Application by RWE Renewables UK Solar and Storage Limited for Peartree Hill Solar Farm (EN010157)

The Examining Authority's (ExA's) second written questions and requests for information (ExQ2)

Issued on 24 September 2025

Figure 1.2: Land Areas and Cable Routes Plan with Field Numbering System

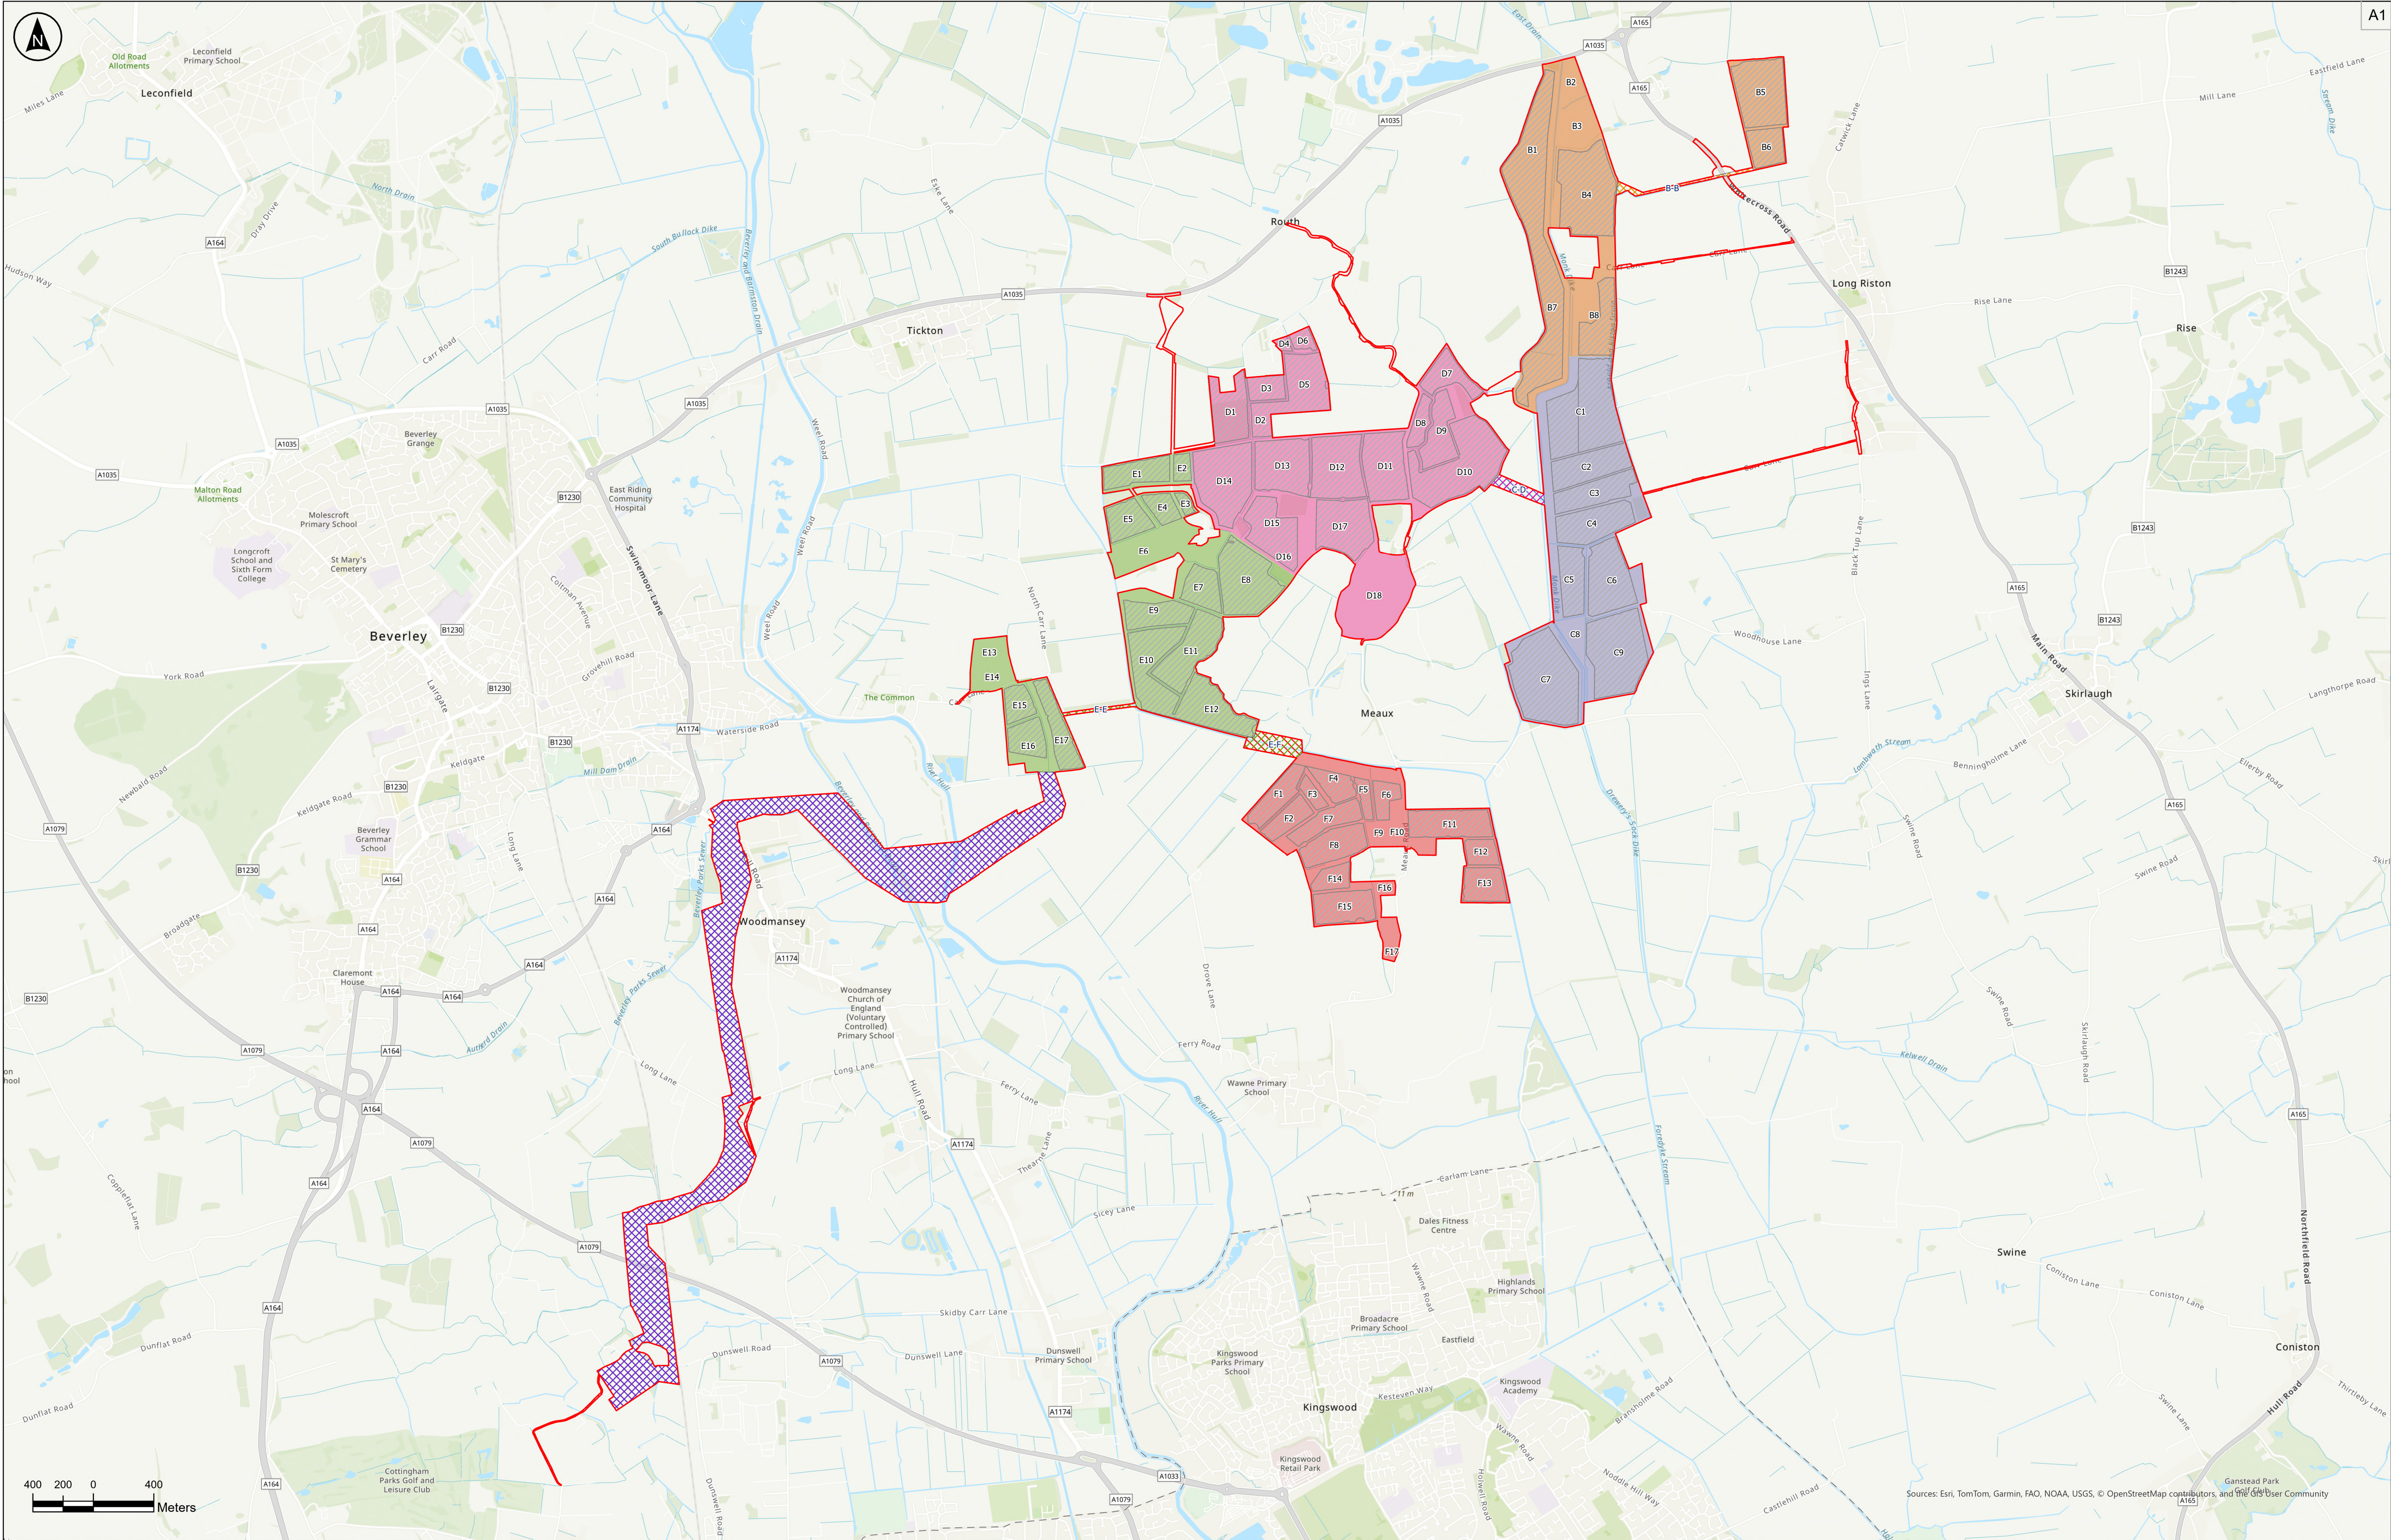
2.13.5	The applicant	Access Regarding fields E15, E16 and E17, please clarify: a) how these fields would be accessed for construction purposes; and b) how these fields would be accessed for maintenance purposes (including replacement of parts), noting that there does not appear to be any internal access tracks on relevant plans linking these fields with, for example, internal access tracks within fields E9 to E12?

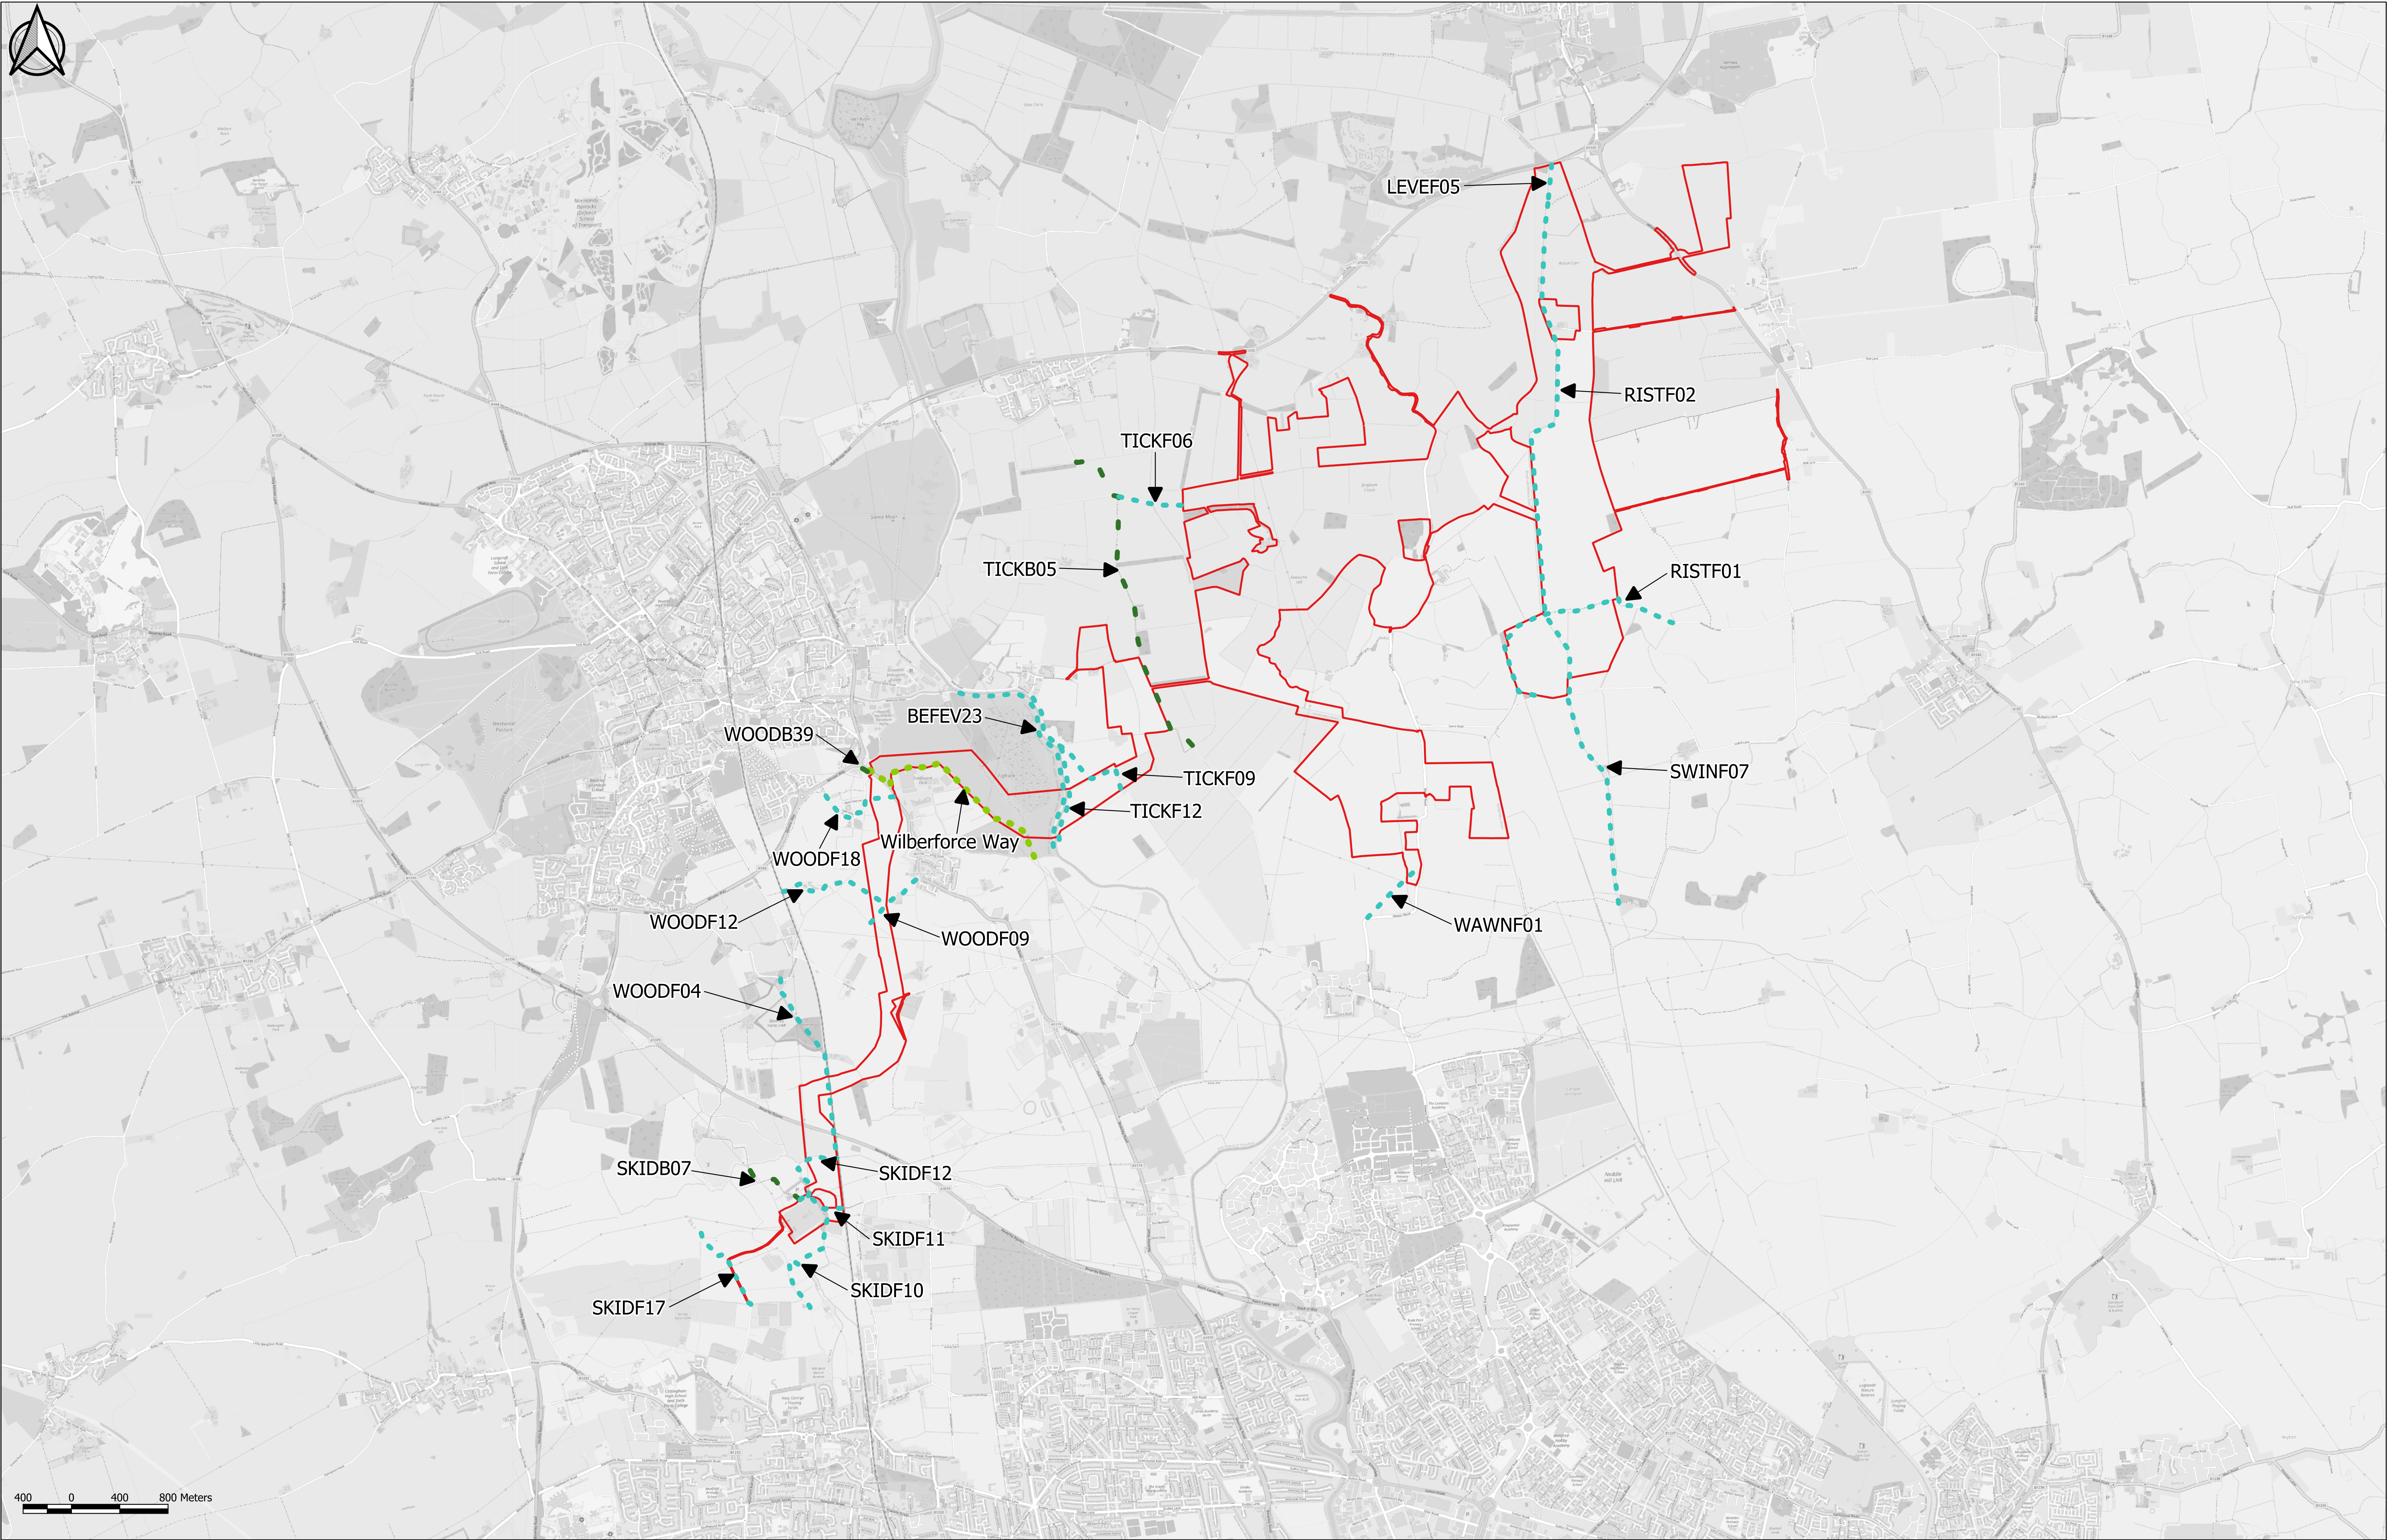
2.2.17	The applicant	Sch 5, Part 2 – a) the ExA notes your response to ExQ1.2.66 [REP1-073]. However, please review the information given in ES Chapter 13 paragraph 13.9.1 [APP-049], noting that the Streets, Rights of Way and Access Plans [REP2-051], the outline Rights of Way and Access Management Plan Table 3-1 [REP2-144] and Sch 5, Part 2 of the dDCO refer to measures the three cited footpaths would be subject to; and b) remove the additional spaces between the words ‘Temporarily’ and ‘restricted’ for Riston Footpath No. 2 and Wawne Footpath No. 1.
